# **MORGAN AND MORECAMBE OFFSHORE WIND FARMS: TRANSMISSION ASSETS**

**Notification of Intention to Submit a Change Request Application**

01 August 2025  
Rev: F02

**Notification of the Applicants' intention to submit a request for changes to the Transmission Assets Application**

**Drawing Number:**  
BP-GBR-MORG-REG-0176

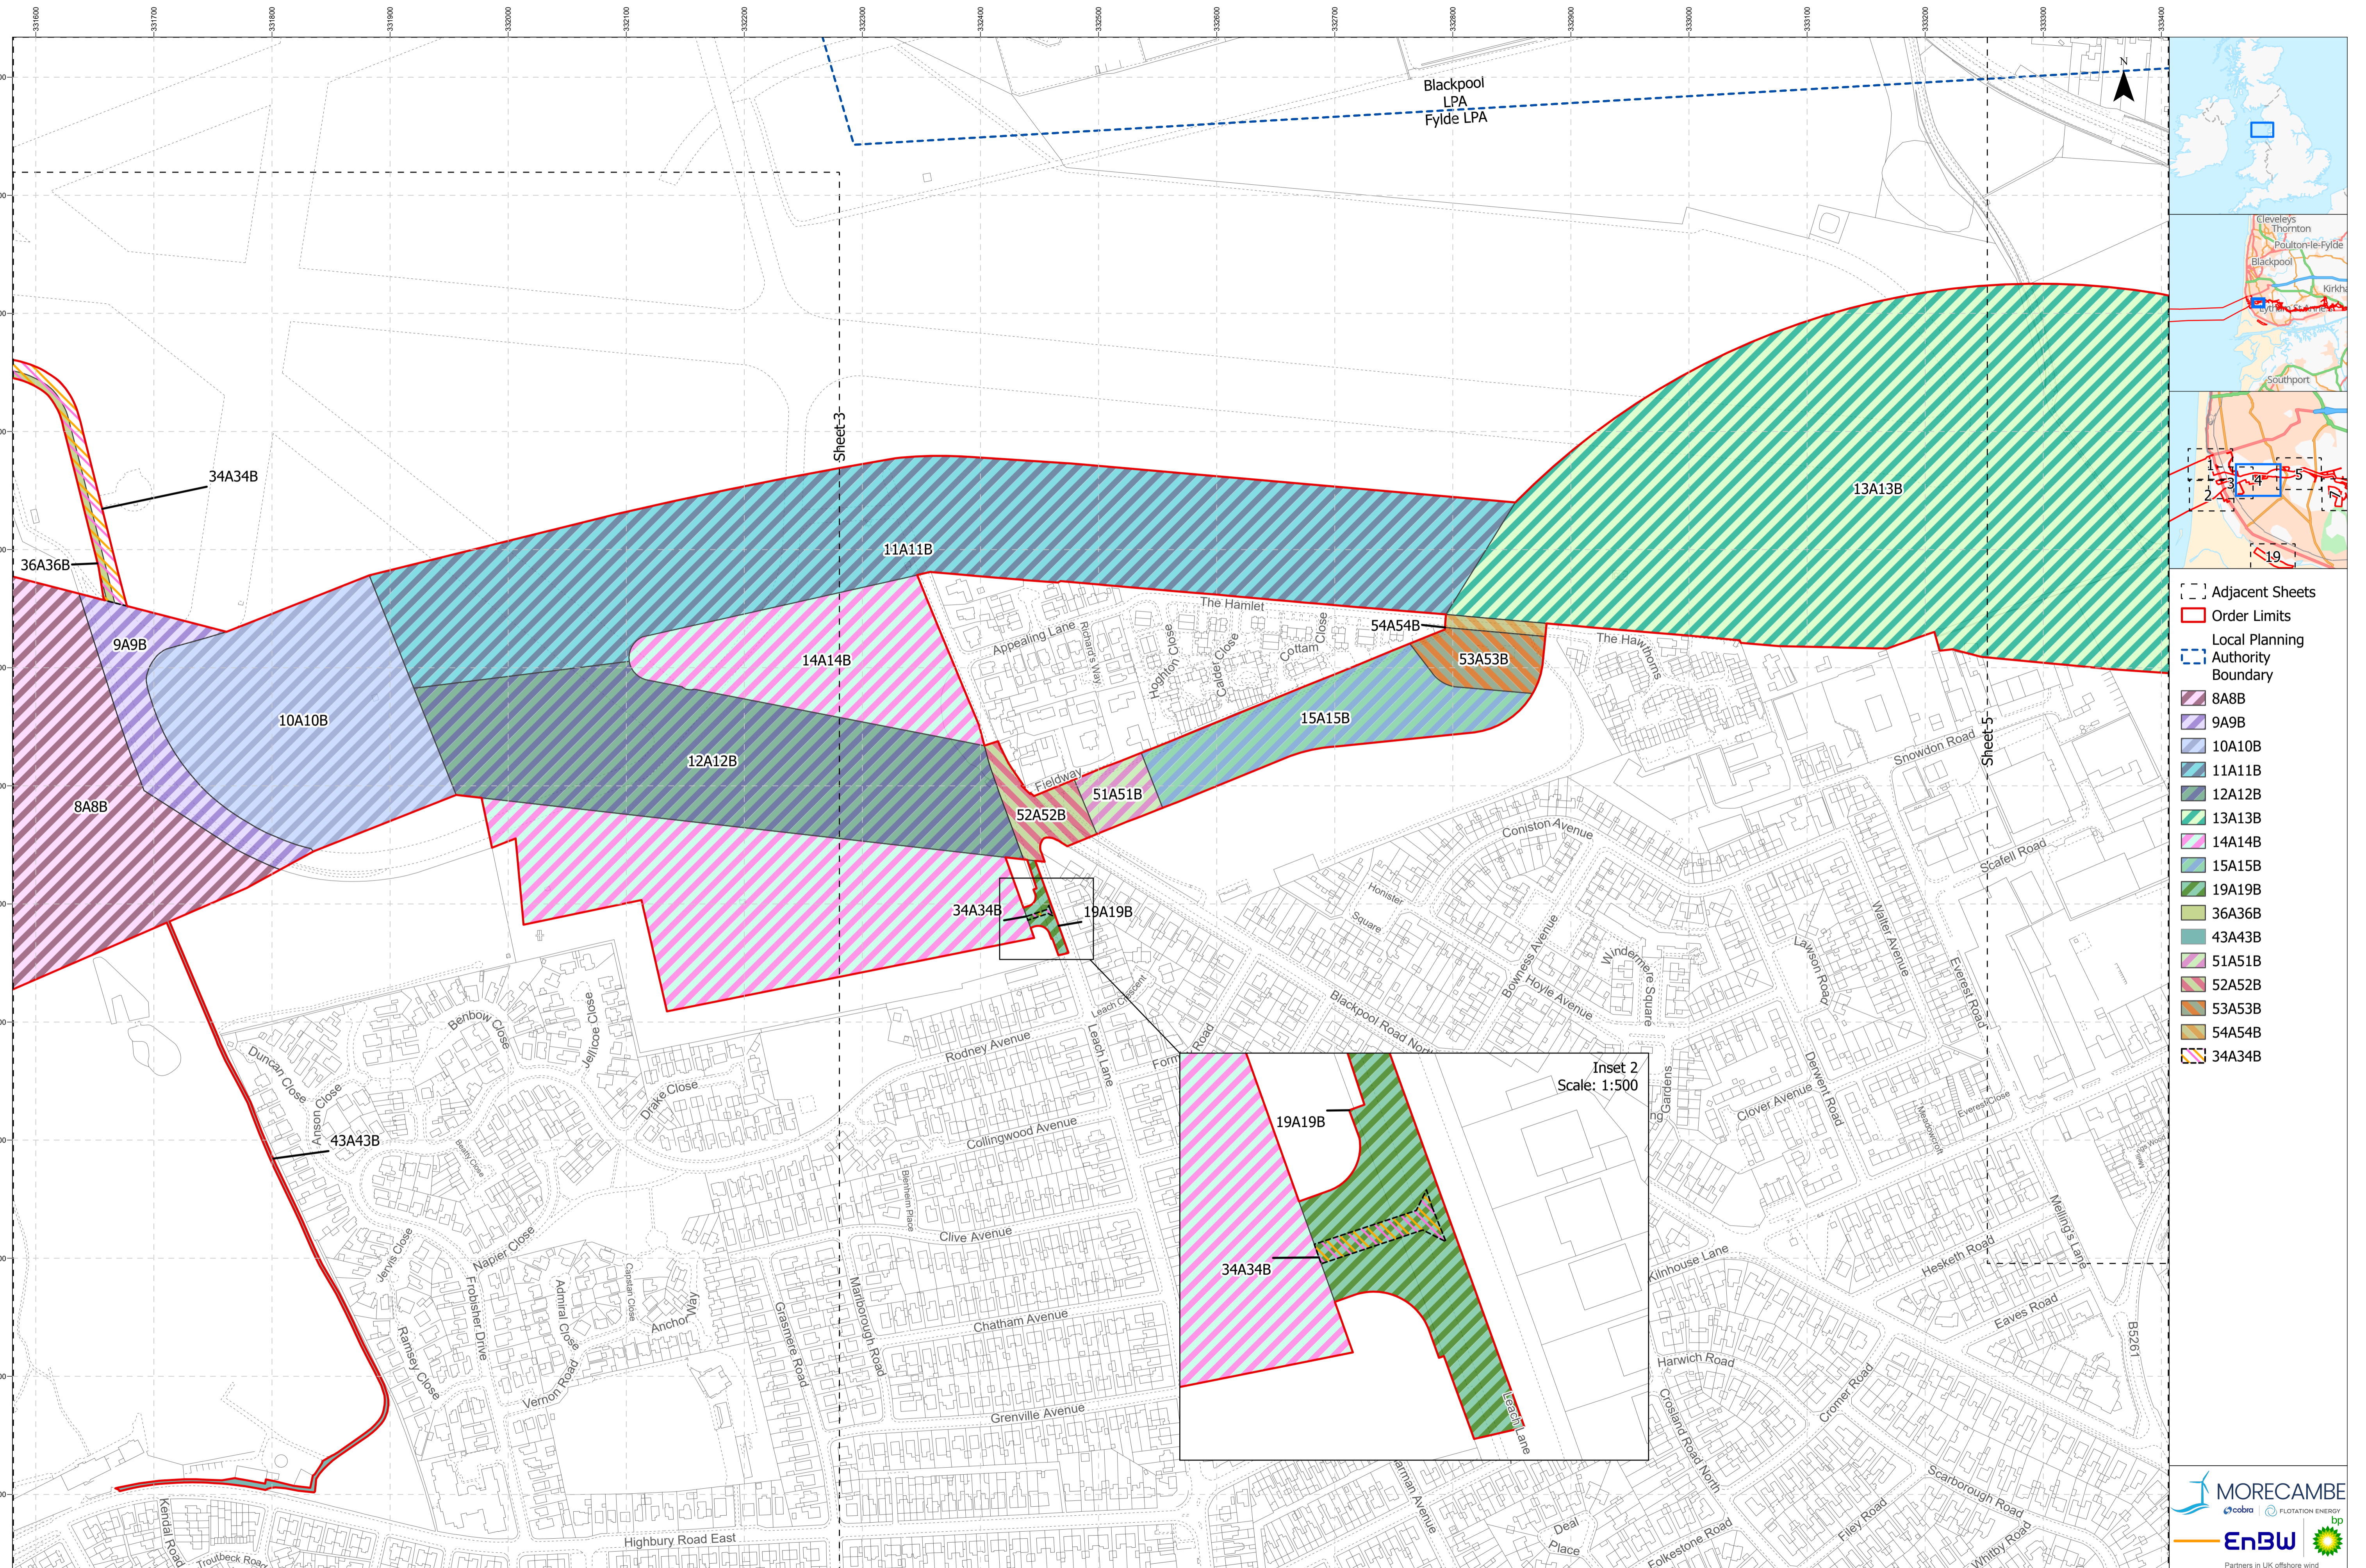
### **4. Change 4a – Reduction to Order Limits within Blackpool Airport (Work No. 13A13B) and Change 4b – Reduction to Order Limits within Blackpool Road Recreation Ground (Work Nos. 15A15B, 53A53B and 54A54B).**

Change 4a involves amendment and reduction of the proposed Order Limits to remove any potential interaction with Runway 10/28 and land north of Runway 10/28 within Blackpool Airport operational land; currently included within Work Nos. 13A13B on Sheets 4 and 5 of the Works Plans – Onshore and Intertidal – Part 1 of 2 (REP3-007). The Applicants have made a commitment through negotiations with Blackpool Airport that cables will not be installed beneath Runway 10/28 and that the runway and land to the north of the runway is considered a restricted area, which means that no installation activities will take place. Therefore, this will result in a reduction of the Order Limits within Blackpool Airport. This involves the reduction in one plot of land (plot 04-024).

Change 4b involves amendment and reduction of the proposed Order Limits to reduce interaction with Blackpool Road Recreation Ground and reduce the interaction with one of the St Anne's Football Club 11-a-side pitches; currently included within Work Nos. 15A15B, 53A53B and 54A54B on Sheets 4 and 5 of the

Works Plans – Onshore and Intertidal – Part 1 of 2 (REP3-007). Following feedback received from Fylde Borough Council and St Annes FC, and due to the commitments made by the Applicants through negotiations with Blackpool Airport not to undertake construction activities in the restricted area (as explained under Change 4a above), the swept path of onshore export cables in the northern section of Blackpool Road Recreation Ground can be reduced. This involves the reduction in five plots of land (plots 04-015, 04-016, 04-017, 04-018 and 04-019). As requested during Issue Specific Hearing 2 on 29 July 2025, the Applicants will provide a figure within the Change Request application which illustrates the change overlaid with the current layout of 11-a-side football pitches at the Blackpool Road Recreation Ground (which the Applicants acknowledge may be subject to future reconfiguration depending on the needs of the users).

**Drawing Number:**  
BP-GBR-MORG-REG-0176

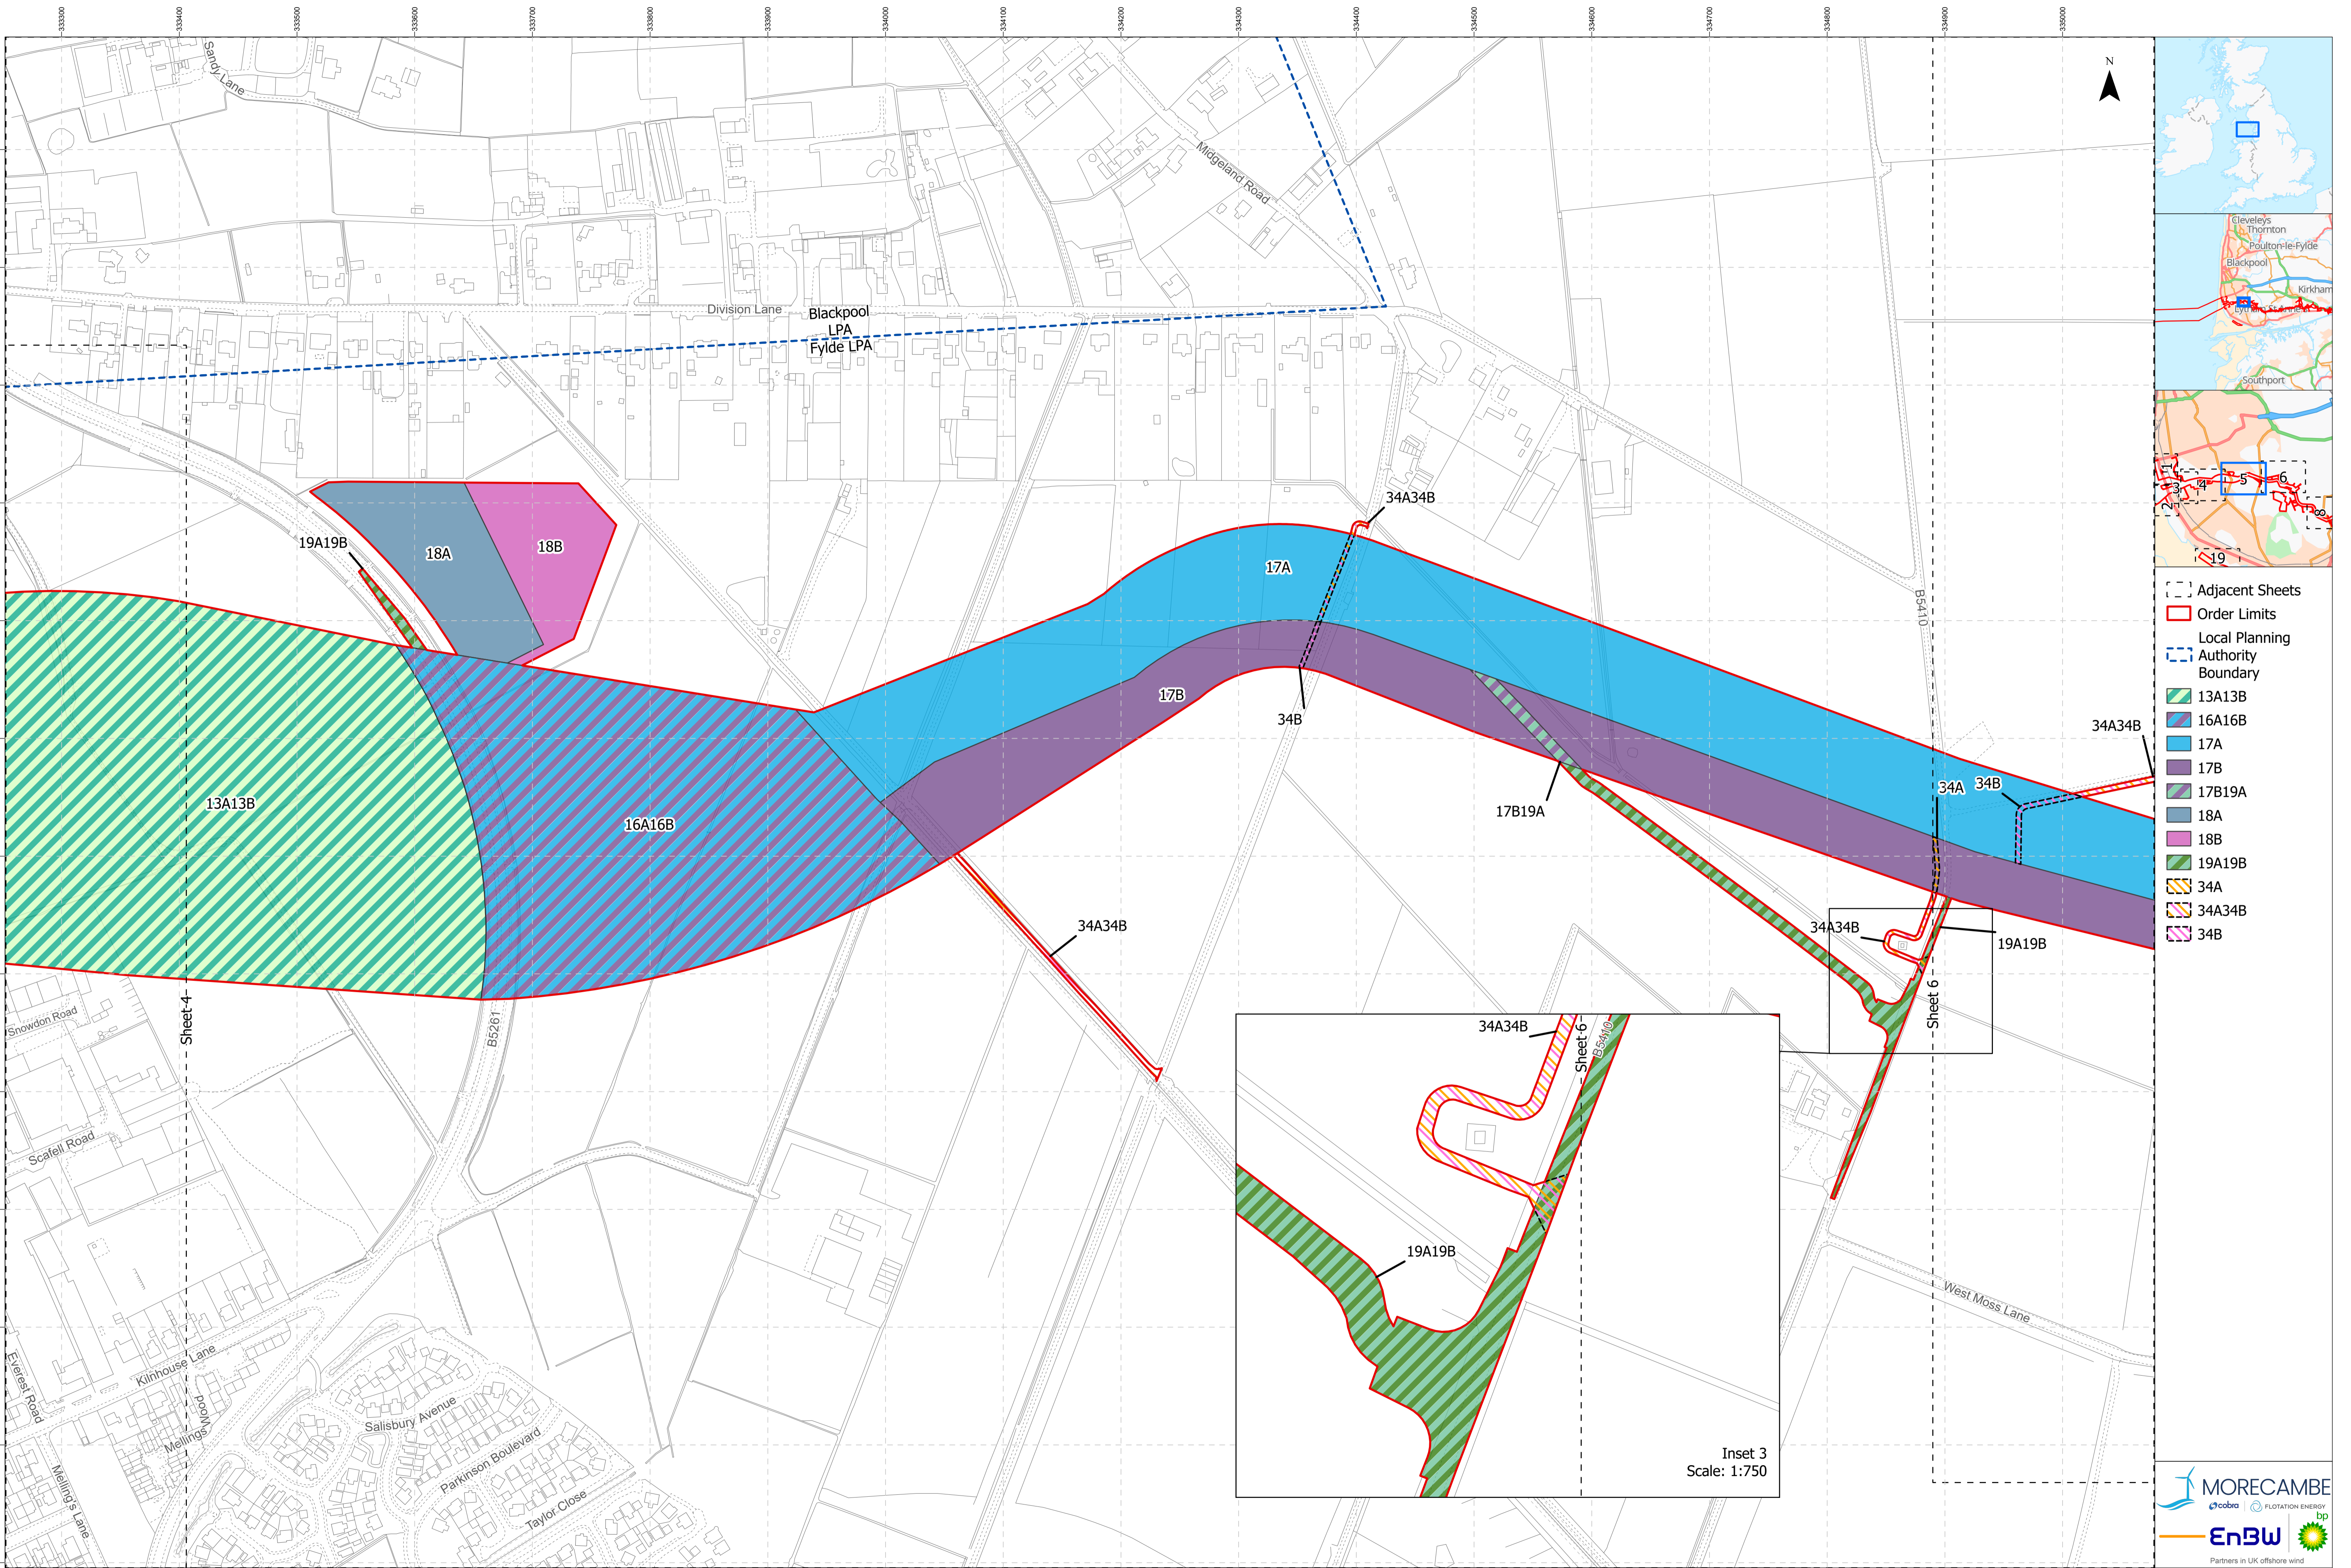
Change 4c involves amendment of the Works Plans – Onshore and Intertidal (no amendment to the proposed Order Limits) to reduce the Order limits east of the Queensway and alter the permanent rights currently sought under part of Work No. 16A16B to temporary possession powers. The commitments made by the Applicants as part of the negotiations with Blackpool Airport to reduce the Order limits to remove a restricted area from Work Nos.13A13B (as explained under change 4a above) result in a consequent alignment of the route of the onshore export cable corridor to the southern extent of Work Nos. 16A16B meaning that the northern extent is not required for permanent rights Access to the onshore export cable corridor is still required from the north so temporary possession powers are still required over this area. The routing of the access required is subject to detailed design as the land east of Queensway is beneath the flight path for Blackpool Airport and contains runway approach lights. This involves changes to seven plots of land (plots 05-004, 05-005, 05-006, 05-007, 05-008 and 05-014A) to reflect the changes to the Works Plans and allocate powers of temporary possession for the undertakers over this area.

Change 4d involves amendment of the Access to Works Plan (APP-157) and Works Plans – Onshore and Intertidal (amendment to the proposed Order Limits is captured within Change 4a) to provide a new point of access to the west of Queensway (B5216) as shown on Sheet 5 of the Access to Works Plan (APP-157). The removal of Order Limits associated with Change 4a would result in Access TAT\_MGMC\_7 and Access OAR\_MGMC\_6 being disconnected from the amended Order Limits. The Applicants have agreed with Blackpool Airport that operational access into the Airport will only be taken from Leach Lane and therefore Access OAR\_MGMC\_6 will be removed from the Access to Works Plans (APP-157).
